SECTION 4.55(1A) MODIFICATION APPLICATION (SSD 7173 MOD 8) FOR PROPOSED AMENDMENT TO THE SUBDIVISION PLAN

PROPERTY AT: 11-19 DISTRIBUTION DRIVE, ORCHARD HILLS (LOT 16 DP 271141)

Proposed Amendment to the Subdivision Plan

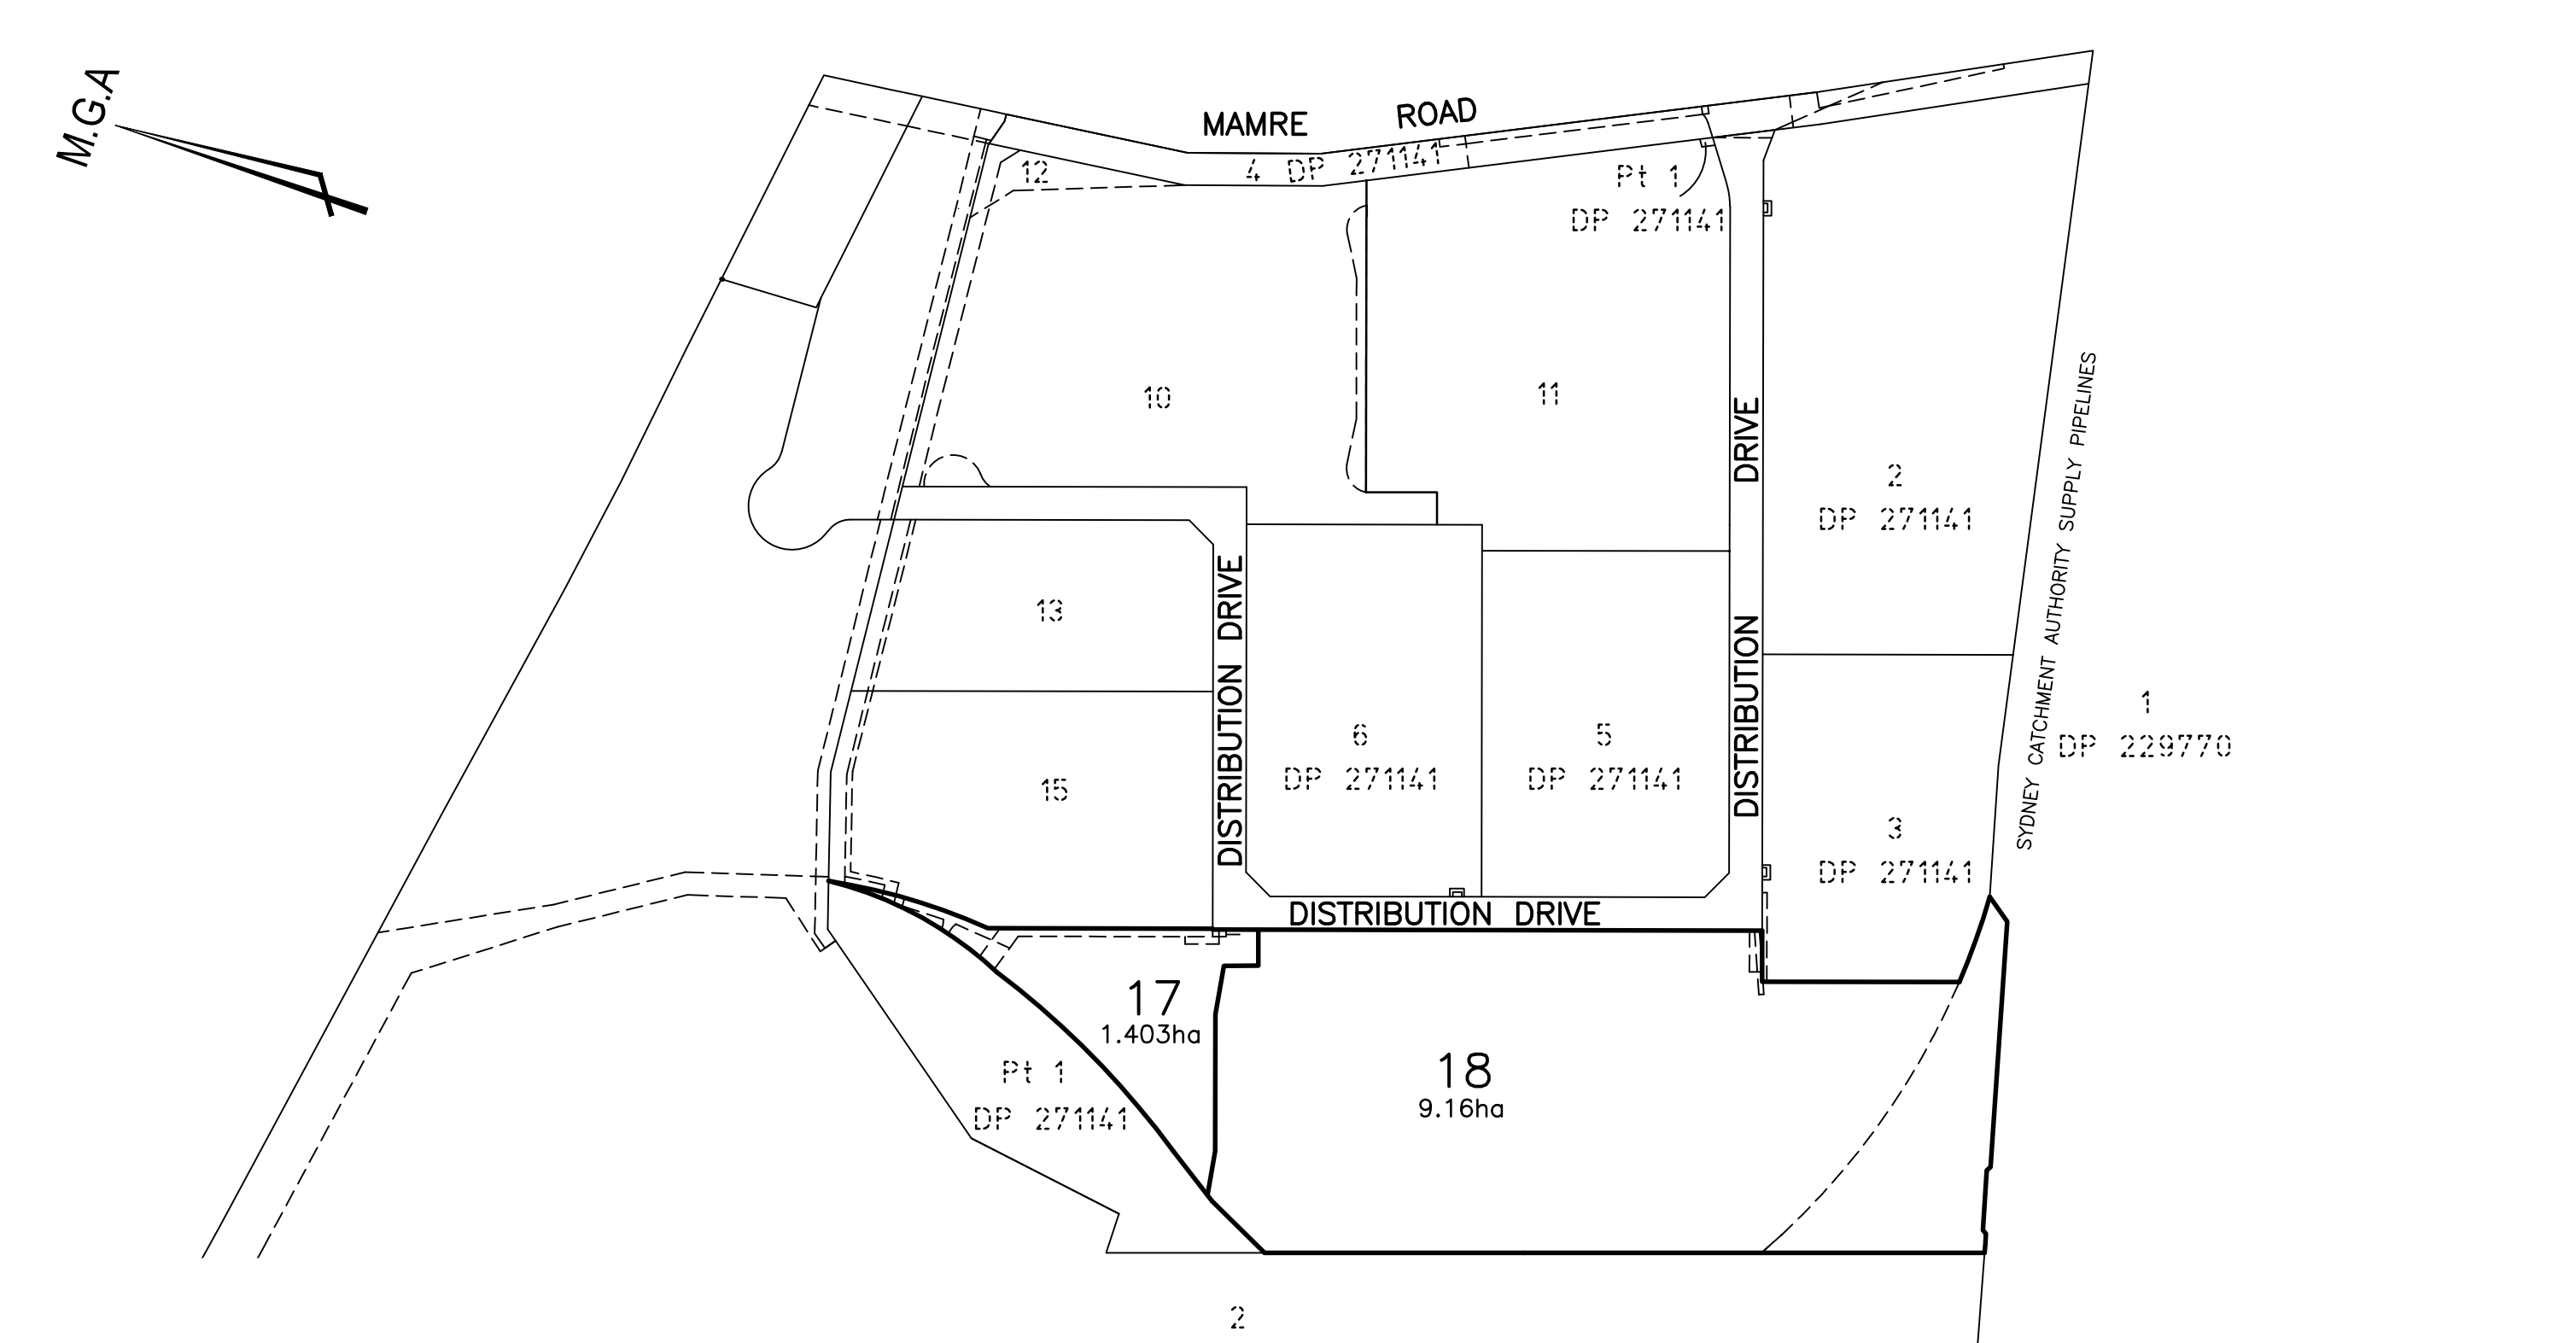
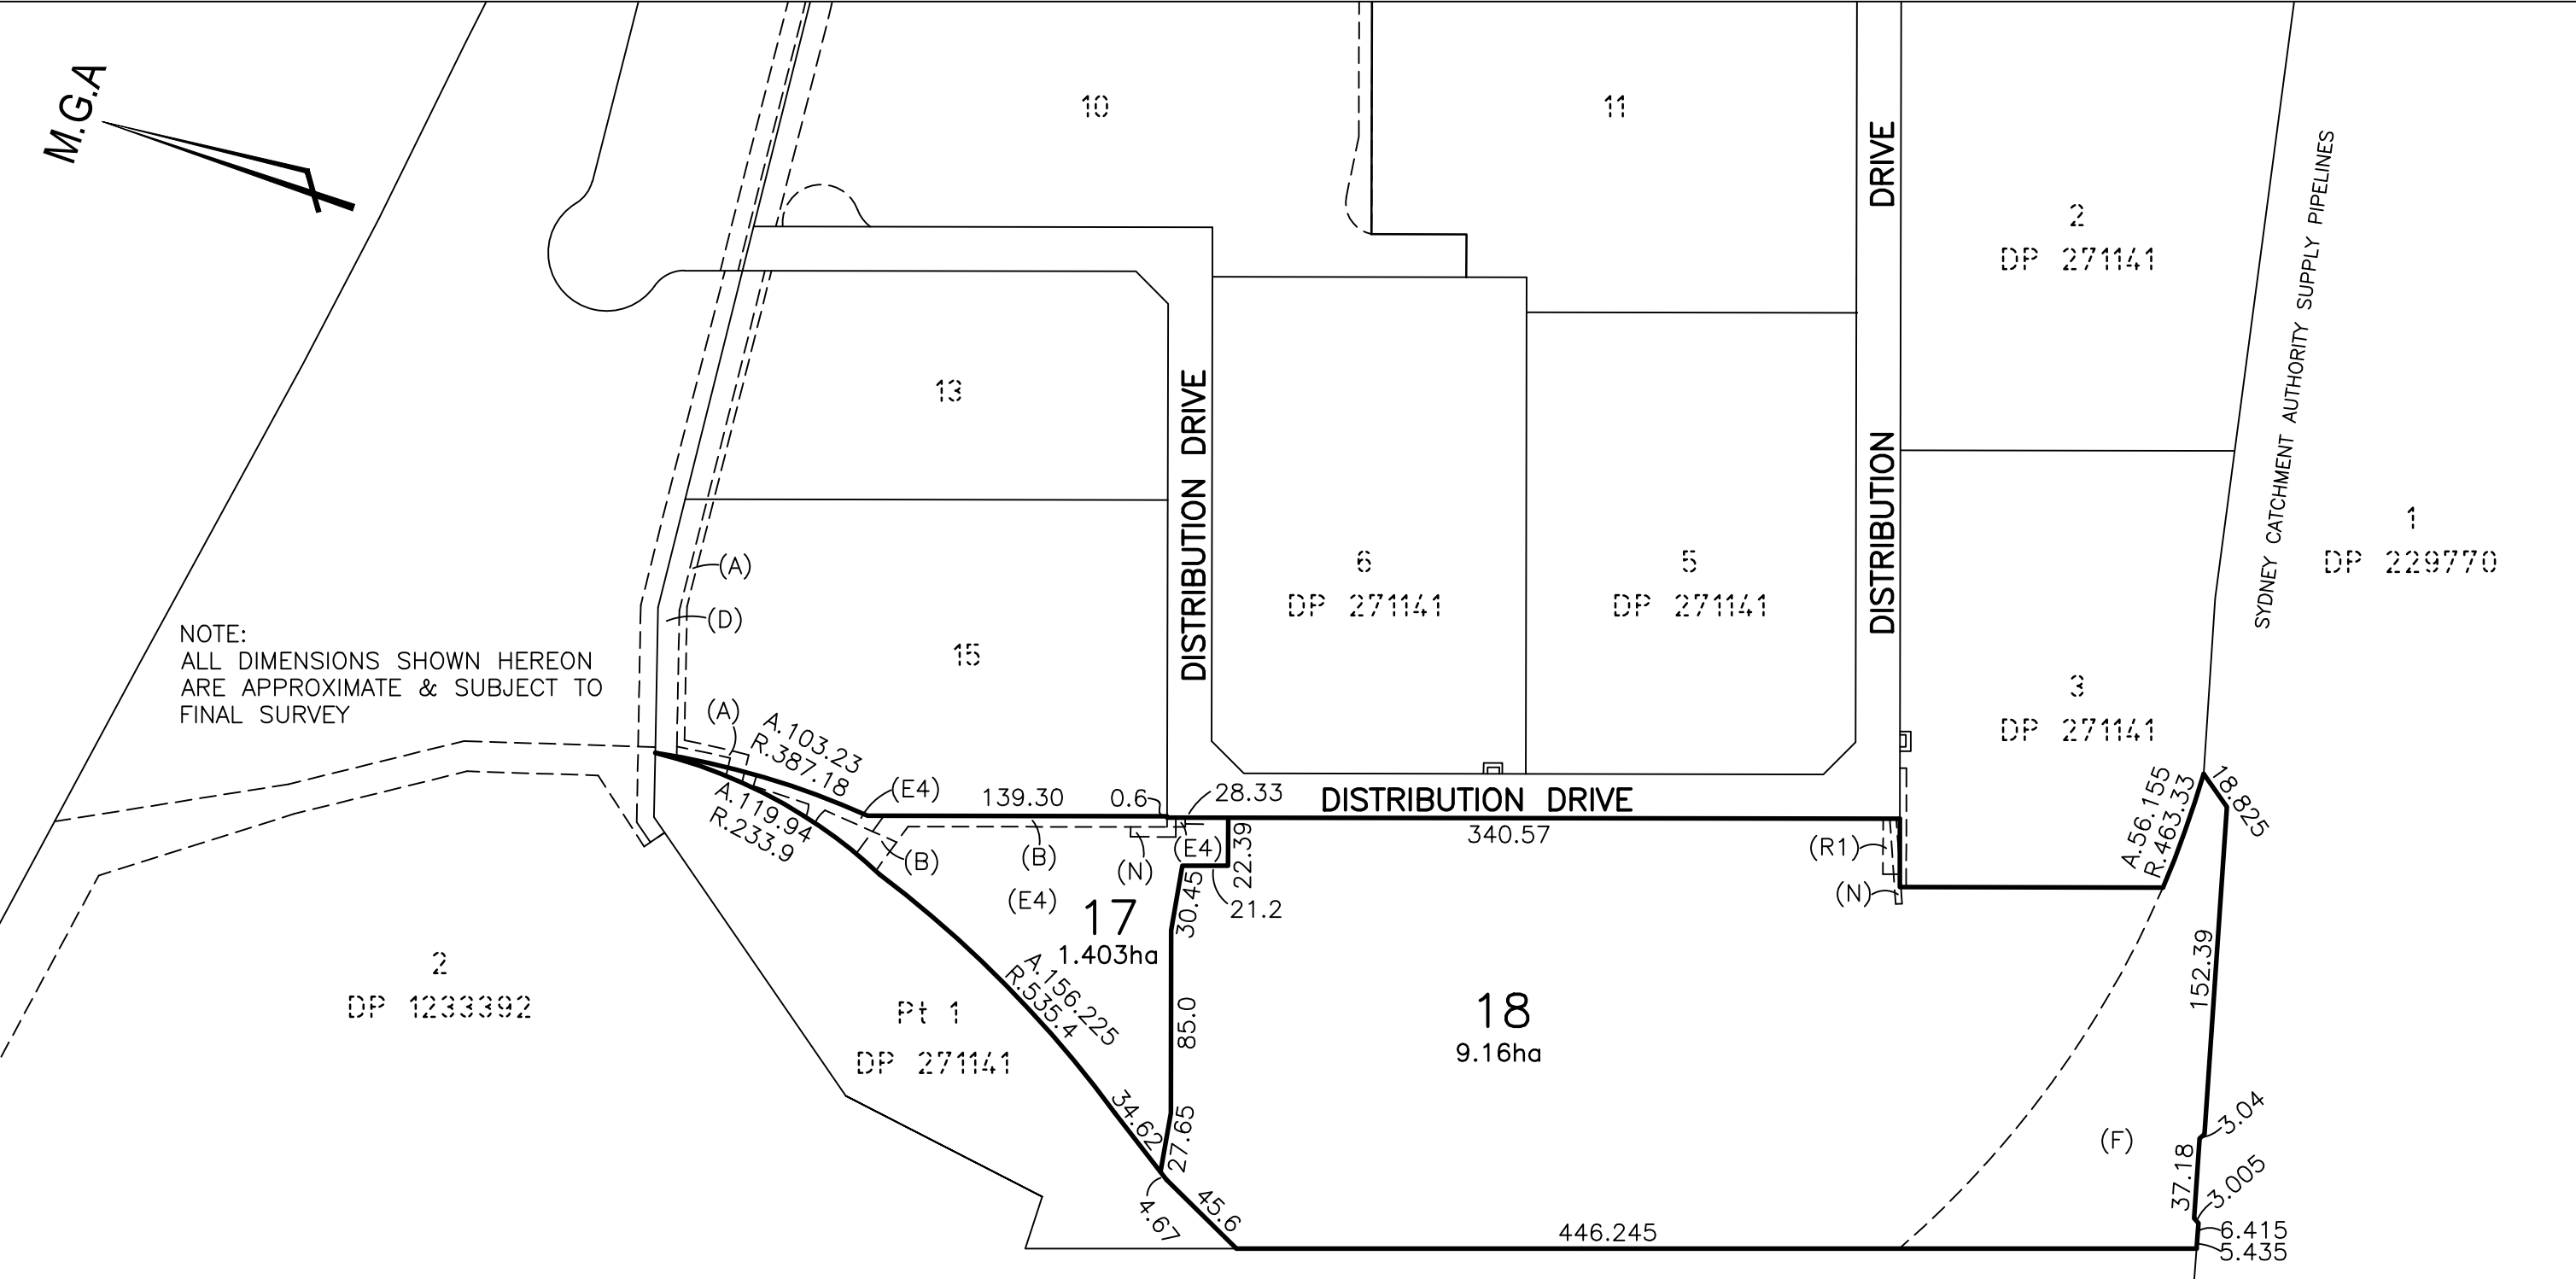
Table 1: Response Matrix	
Relevant Entities Response to Submissions	Formalised Response
Penrith City Council (Gavin Cherry – Development Assessment Coordinator)	
<i>It would appear that the SSD modification seeks to respond to the recent approval of DA 19/0897 and proposes to establish a subdivision pattern that reflects the lease boundaries of the subject land as indicated in that Development Consent. There are however discrepancies between the detail approved within the DA and the proposed plan of subdivision that need to be rectified.</i> <i>The indicated dividing boundary between Proposed Lot 17 and 18 is depicted within the SSD Mod 8 as a straight alignment. However, DA19/0897 as approved does not set up a straight regular boundary alignment and this is required to ensure clearances of the approved driveways to each development. Refer to the stamped approved plans attached to this letter.</i> <i>The proposed plan of subdivision should be amended to reflect the allotment / lease boundaries established within DA19/0987, as the current boundary dissects the perimeter driveway for the built form on Proposed Lot 18 which is not appropriate. The proposed plan of subdivision and dividing boundary between Proposed Lot 17 and Lot 18 must be consistent with the boundaries established within DA19/0897 and clear of works approved. The stamped approved Site Plan best reflects the required boundary dimensions and allotment shape for Proposed Lots 17 and 18.</i>	The Subdivision Plan proposed has been amended accordingly to ameliorate any inconsistencies with the boundaries in accordance with the Stamped Plans approved under DA19/0897 (refer to Appendix 1).

<i>In addition, if the proposed amended subdivision occurs and divides existing Lot 16, then the registration of a drainage easement through proposed Lot 17 to the benefit of Proposed Lot 18 will need to be established and conditioned accordingly.</i>	Noted and agreed.
